Development Facilitation Team (DFT) – Review Comments

Project No: PR-2023-008999

Date: 02/28/2024

REQUEST: BULK LAND PLAT INNOVATION PARK III TRACTS A-N

BULK LAND PLAT
INNOVATION PARK III
TRACTS A-N
 (BEING A REPLAT OF TRACT 18 ARTISTE)
 CITY OF ALBUQUERQUE
 BERNALILLO COUNTY, NEW MEXICO
 JANUARY, 2024

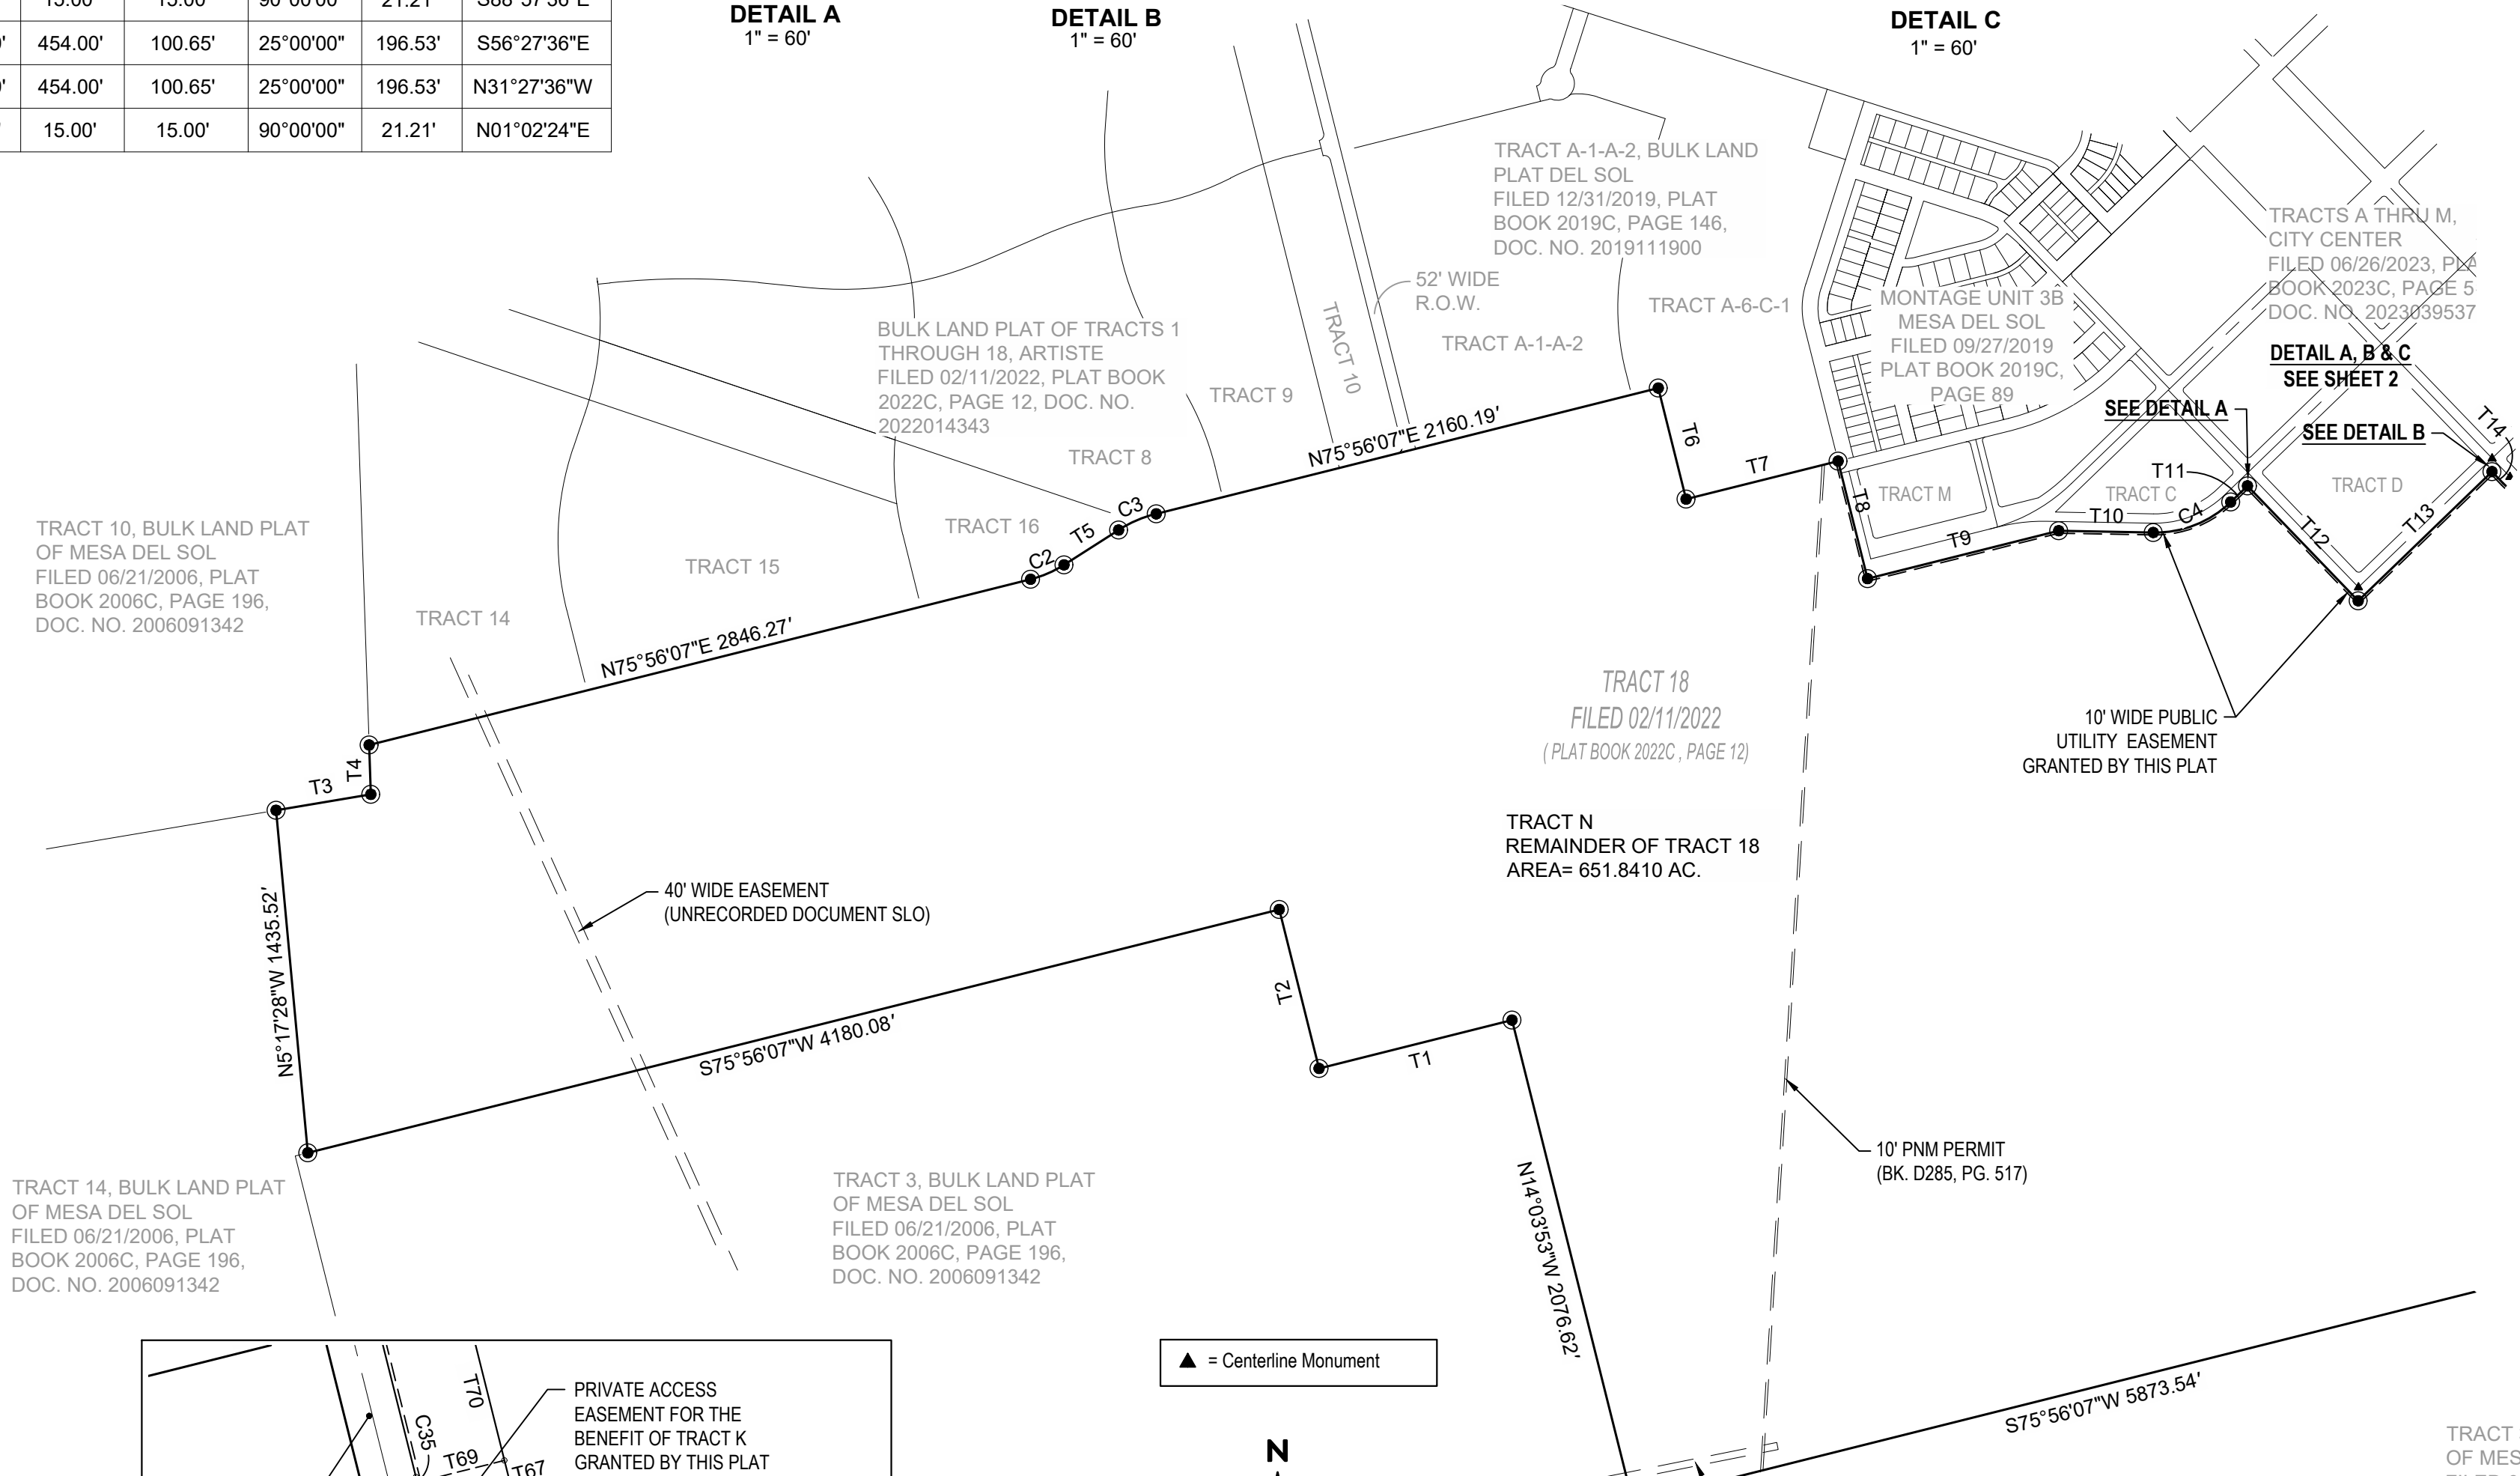
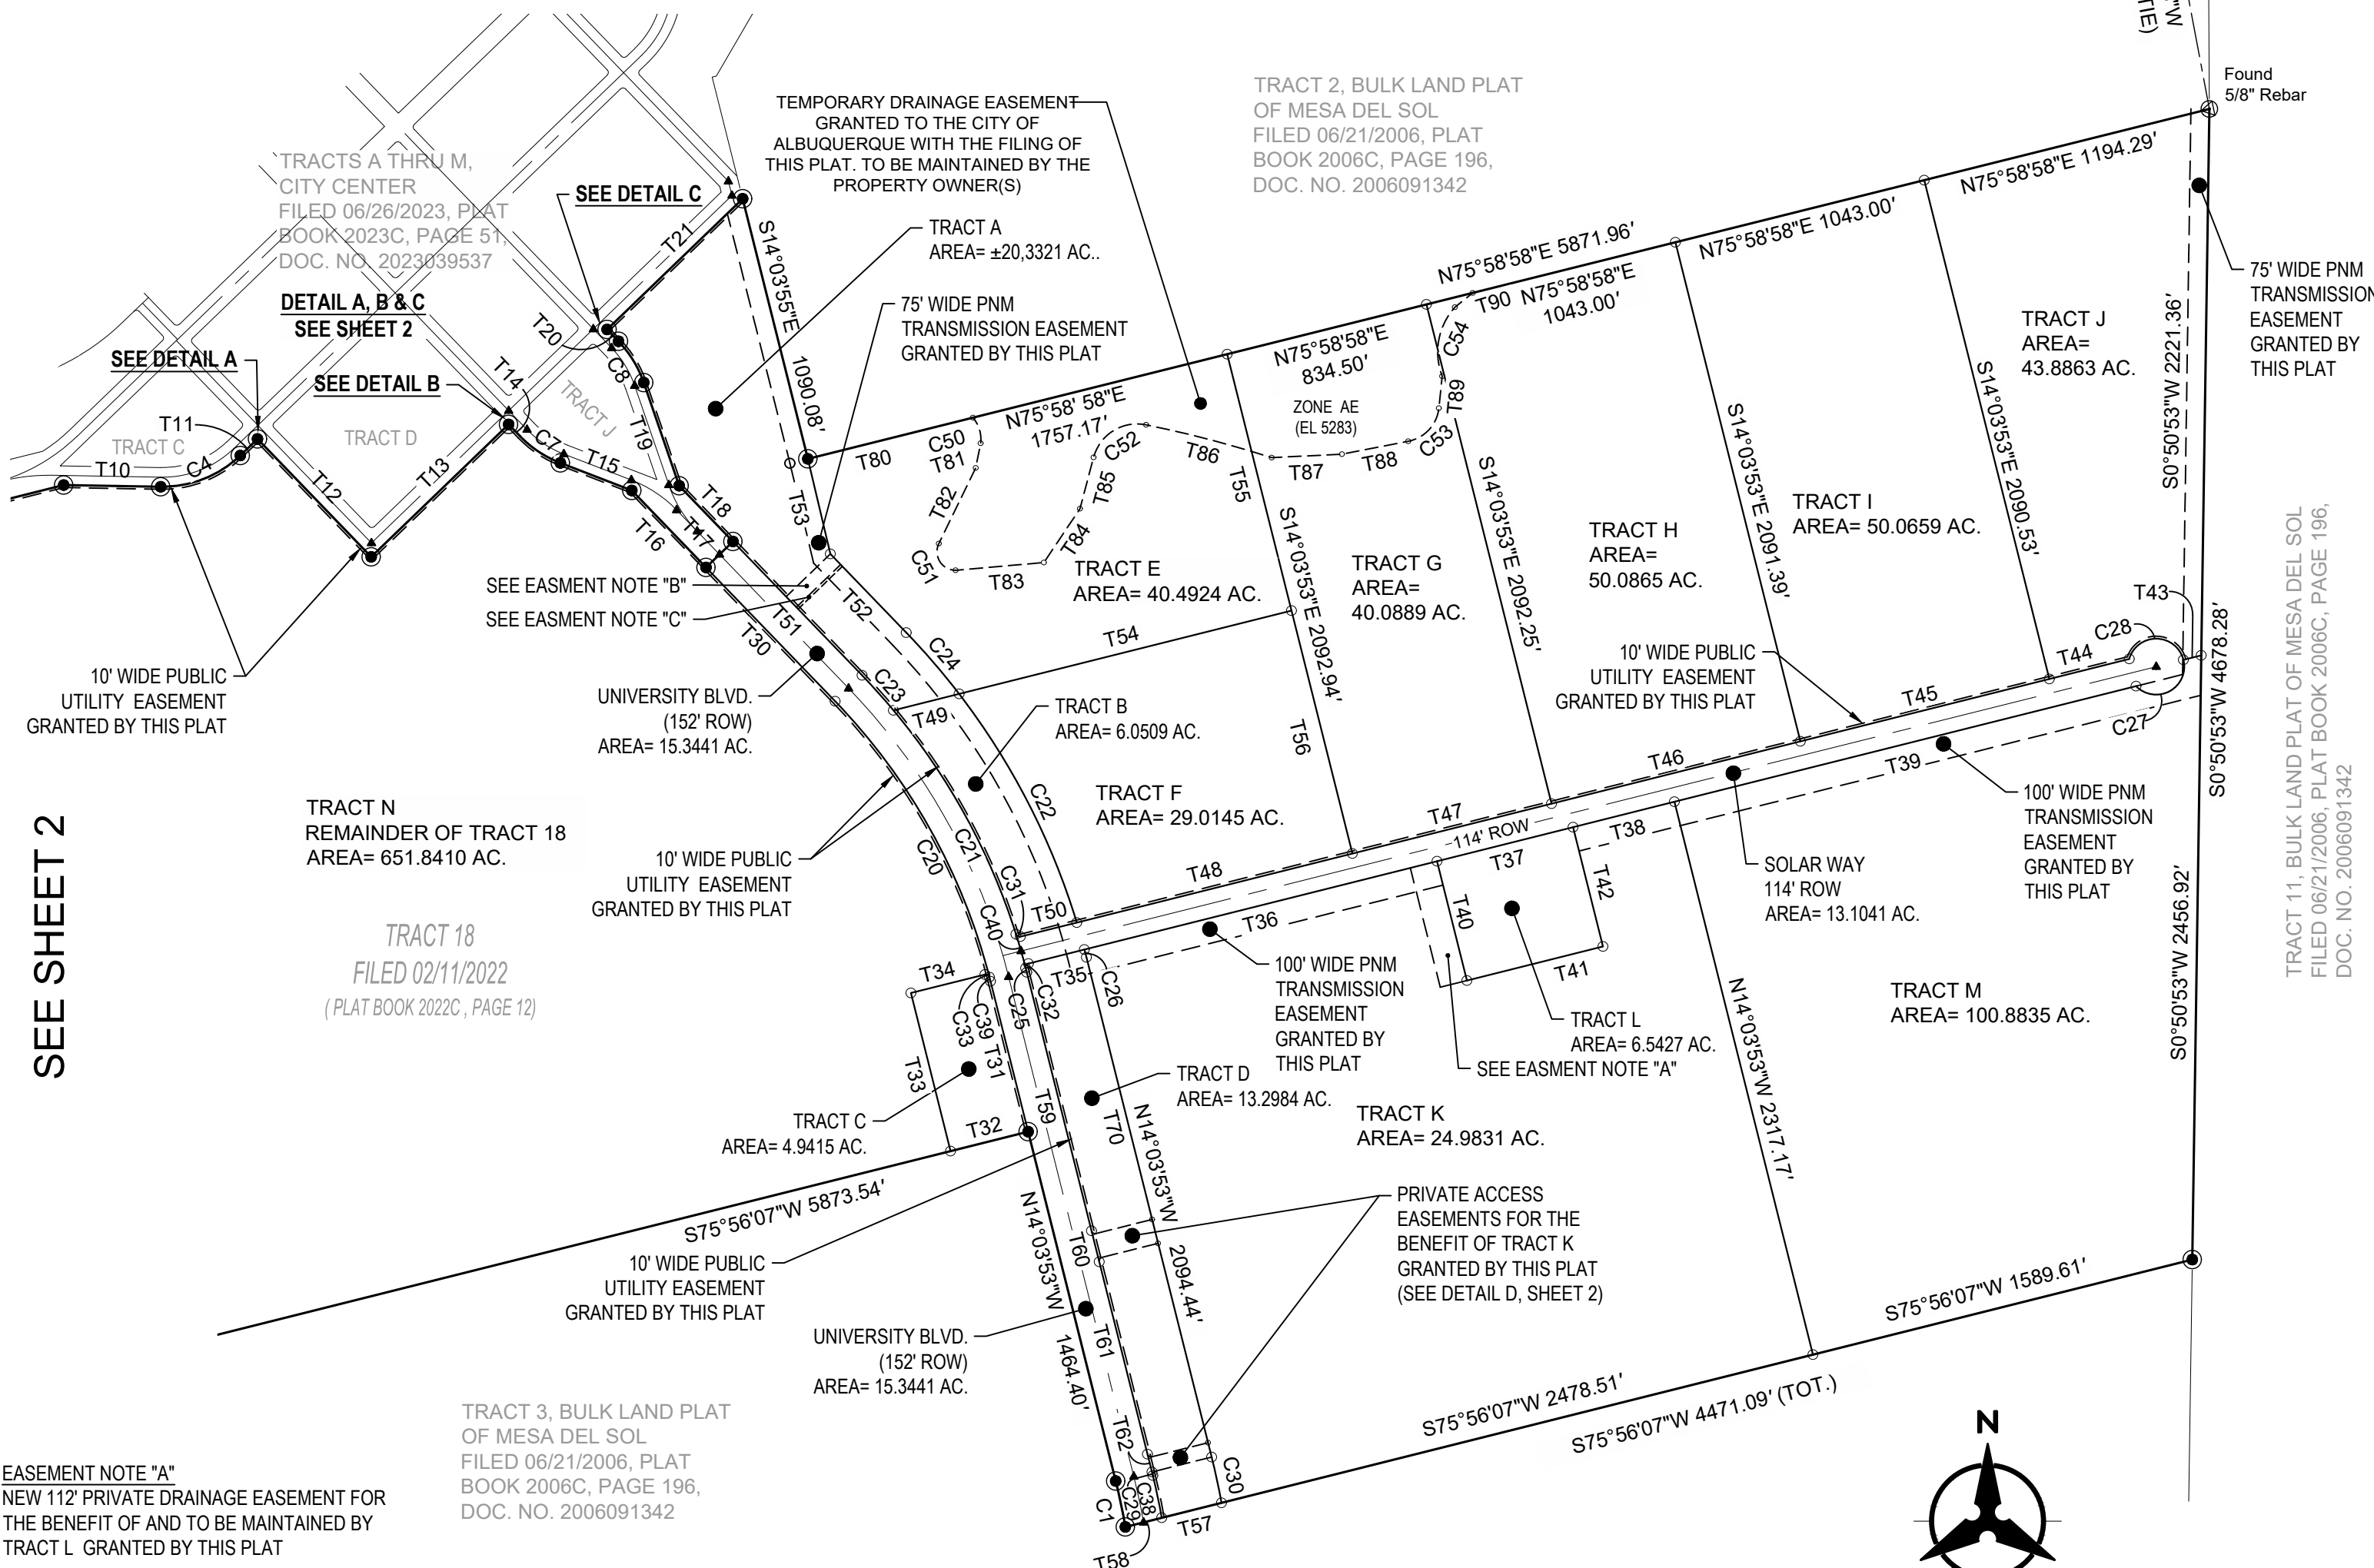
a. How will Tract 11, get service?

i. Please provide a public water and public sanitary sewer easement across Tract M or J to make the connection.

- The acreage for Tract K appears to be incorrect; Tract K is depicted as being 24.9831-acres in size on the Plat, while the site area of the Site Plan Administrative DFT currently under review on the site is approximately 125-acres. Please confirm if the acreage for Tract K is incorrect, and correct the acreage for Tract K on the Plat if needed.
